19th March 2019

Re: Application FP/30/19/PL No 10 South Road
Re-submission following FP/234/17/PL

Elevations

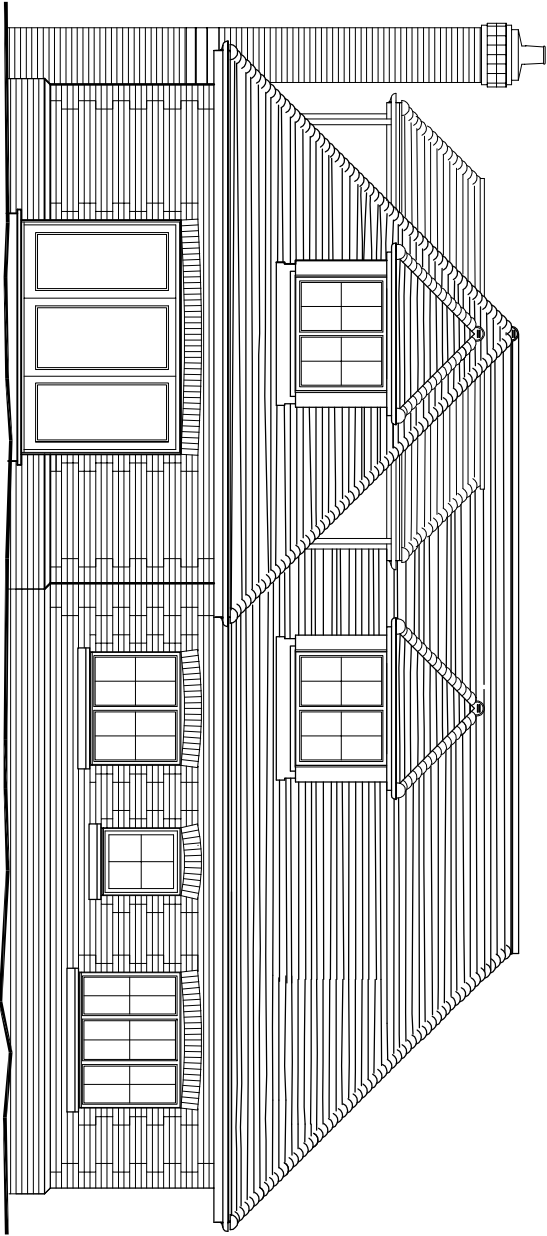
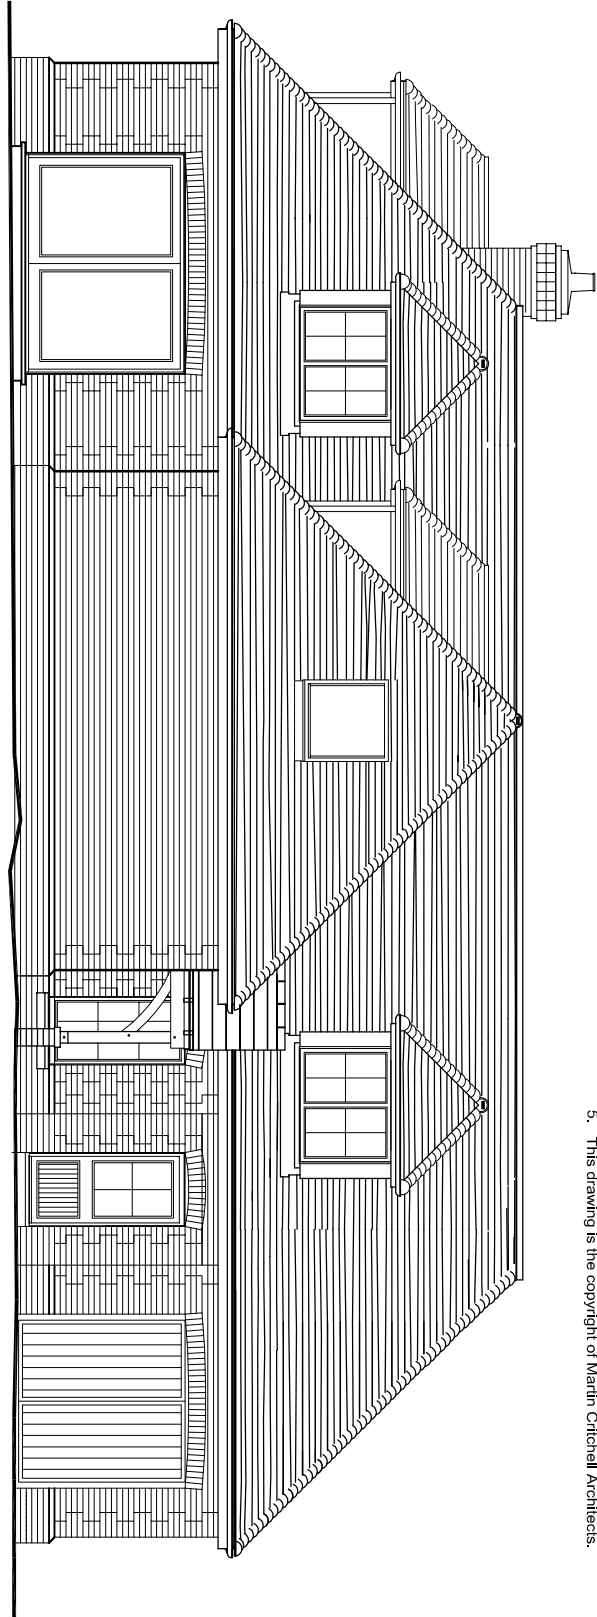
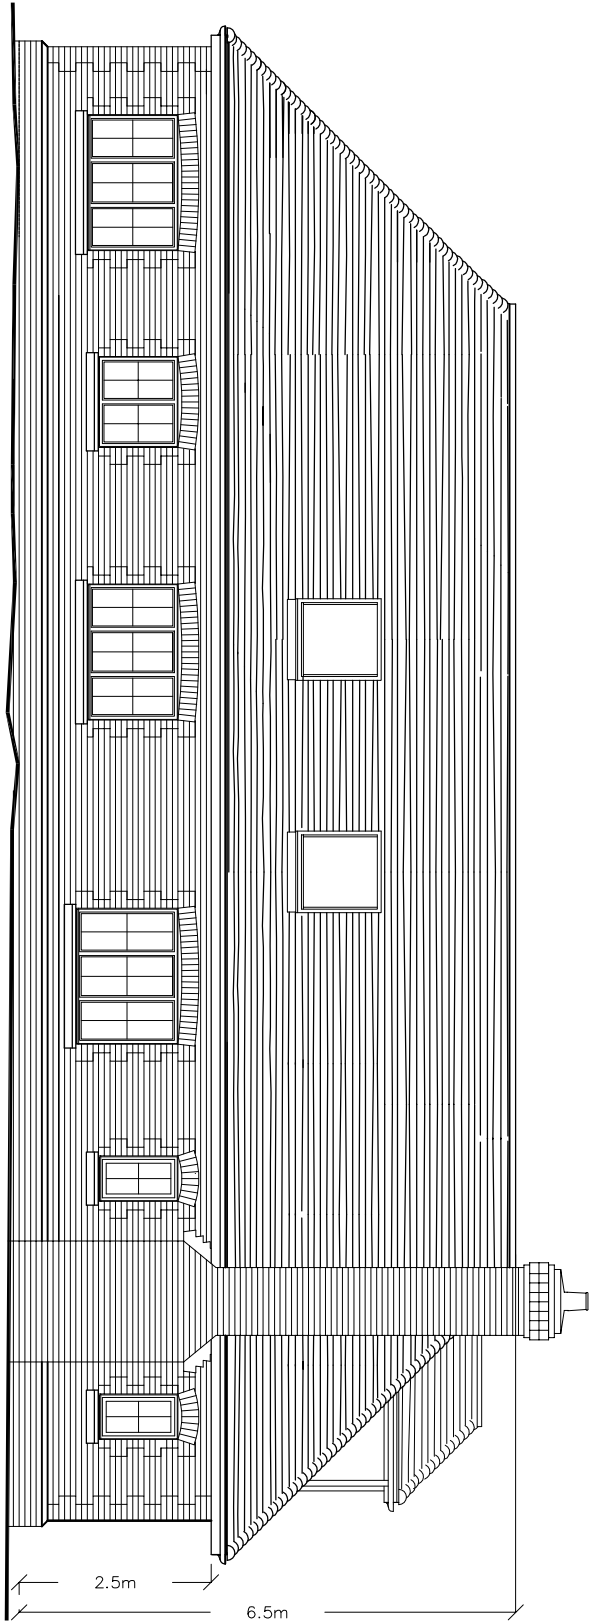
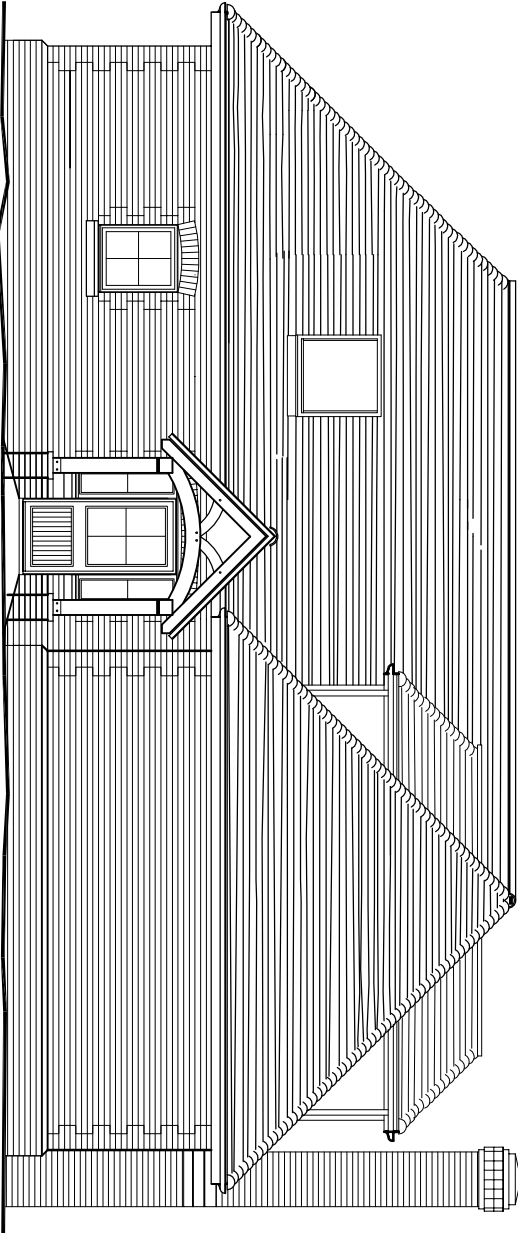
Over the currently submitted drawings we find -- exactly as before -- that there is an abundance of pleasing cosy dormer windows. So many that something seems to be wrong and on closer inspection we find that at least one is still a ghost.

Below are portions of the chalet's north and south aspects showing at least one dormer window facing west, while below these again is the western aspect, which clearly shows none and the internal layout would not work with any either.

While on this we noticed another curious inconsistency in that the chimney, when shown in the east and west aspects, is taller than when shown in the north and south aspects.

Not content with the chimney fiddling so far explained, chimney 'presence' has been further enhanced in the eastern aspect by drawing it in front of, rather than behind, the south facing dormer:
